Planning Application Ref: **AW/342/20/T**

Location: **8 Arun Way, Aldwick Bay Estate, PO21 4HF**

Description of works: **Removal of dead wood from 3no silver birch (T1,T2 and T4) Removal of dead wood from 1no. oak (T3) Removal of dead wood from 2no Lombardy poplars (T6 and T7) Crown reduction of 4no purple beech (T5) to height of 17m and spread of 8m, (T9) to a height of 17m and spread of 8m, (T10) to a height of 17m and a spread of 8m, (T12) to a height of 17m and a spread of 8m Crown reduction of 2no Persian ironwood (T8) to height and spread of 4m , (T11) to a height and spread of 4m**

PAGE ONE

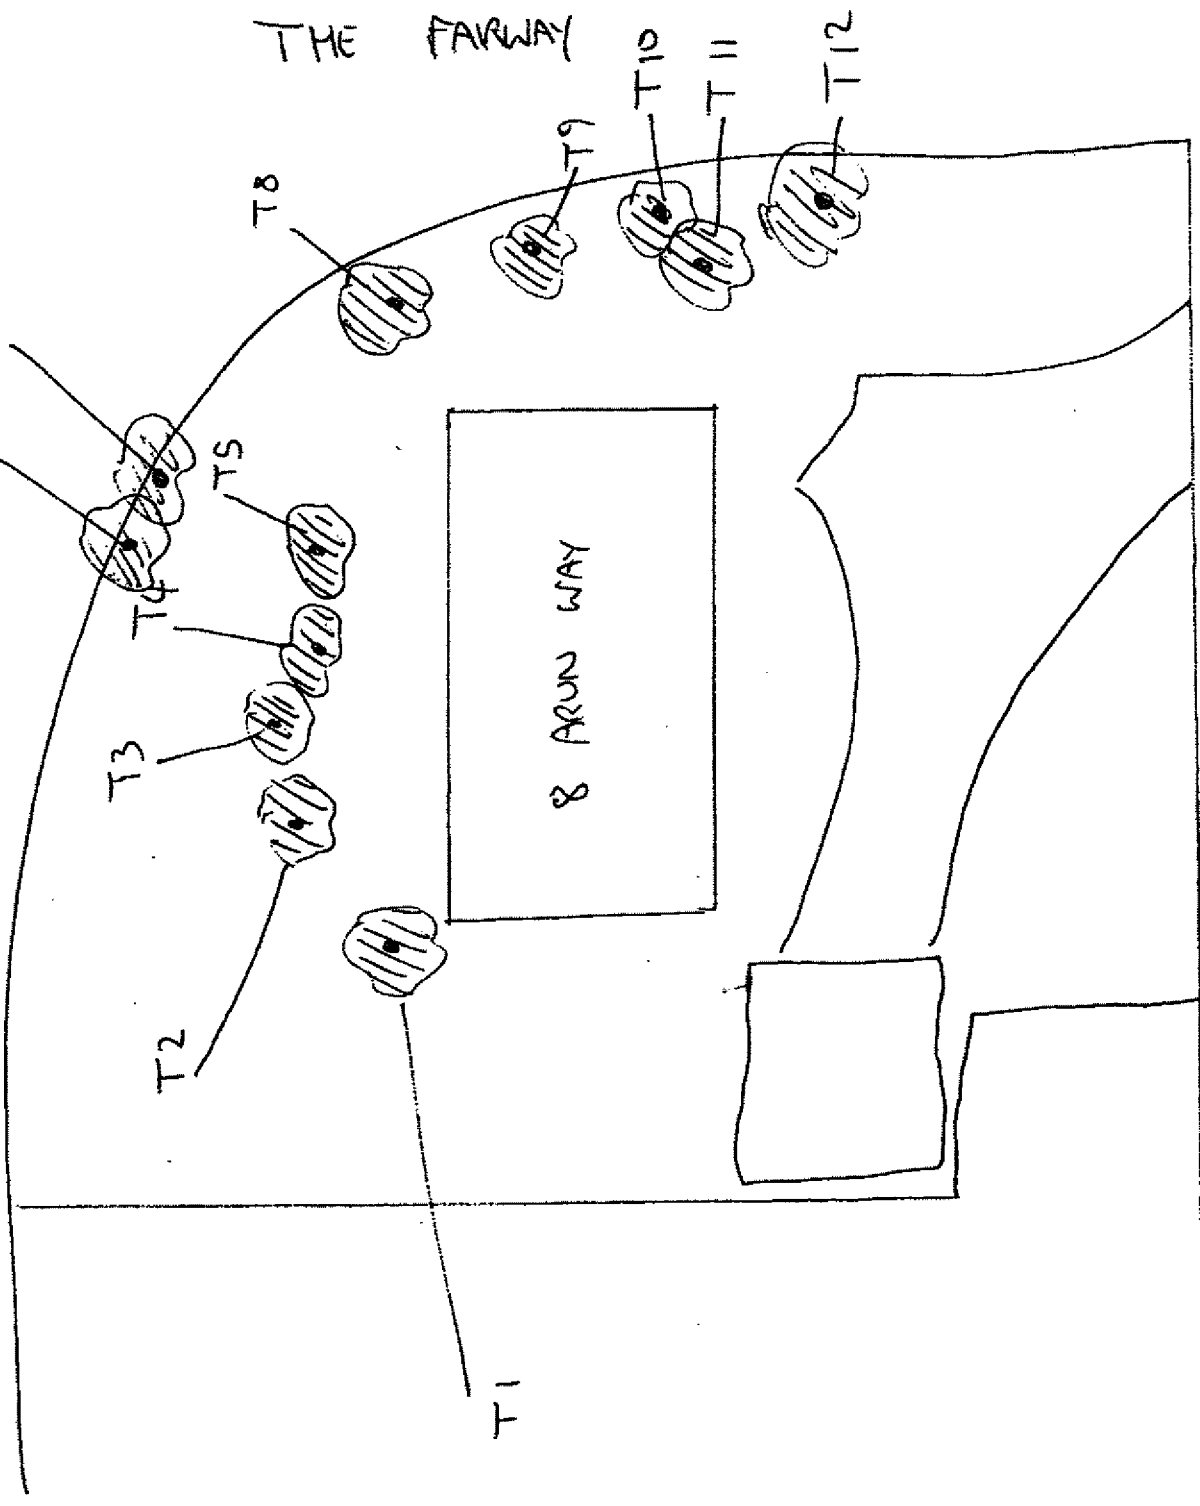
- T5 is discreetly located within the garden interior. Outwardly and from distance (roadside) it appears to be in a fine physiological state with evidence of past reduction of selected branches, presumably to restrict its influence over adjacent dwelling and garden.

- T8 & T11 are undoubtedly of visual interest and have characteristically erratic form, exacerbated by their situation beneath dominant beech (T9, T10, T12). Outwardly and from distance (roadside) they appear to be in a fine physiological state.

- T9, T10, T12 grow prominent and equidistant along the north boundary and are collectively a significant feature with landscape value. Their unmodified upper crowns and apparent good health (restricted view of stem base/ground) qualify them as trees of high amenity value.

- The majority of work proposed is justified on arboricultural grounds.
- T5, T8 & T11 - While a temporary loss of aesthetic value is inevitable, satisfactory canopy renewal and recovery should occur if the work is undertaken to a high standard and at an appropriate time of year.
- Notable exception is that proposed for T9, T10, T12. Collectively and individually these trees are a significant feature in the local landscape and assumed to be in adequately sound and healthy condition. The tree surgery proposed in the

application would result in excessive reduction of their landscape impact and undue detriment to the visual amenities of the locality.

- As it stands, I recommend **REFUSAL** for this application.
- **I would like the applicant to be invited to agree to a revised proposal for lesser works** (such as described below) as part of the current application so as not to incur further delay. Such work would go some way to addressing their concerns whilst preventing a diminution of the trees (T9, T10, T12) landscape and public amenity value:
- T9, T10, T12 Replace *crown reduction* proposal with *crown lift on north aspects only to provide maximum 5metres overhead clearance above carriageway*

-
- If the applicant is prepared to re-submit in line with this advice, then I would be able to recommend APPROVAL subject to the following condition:
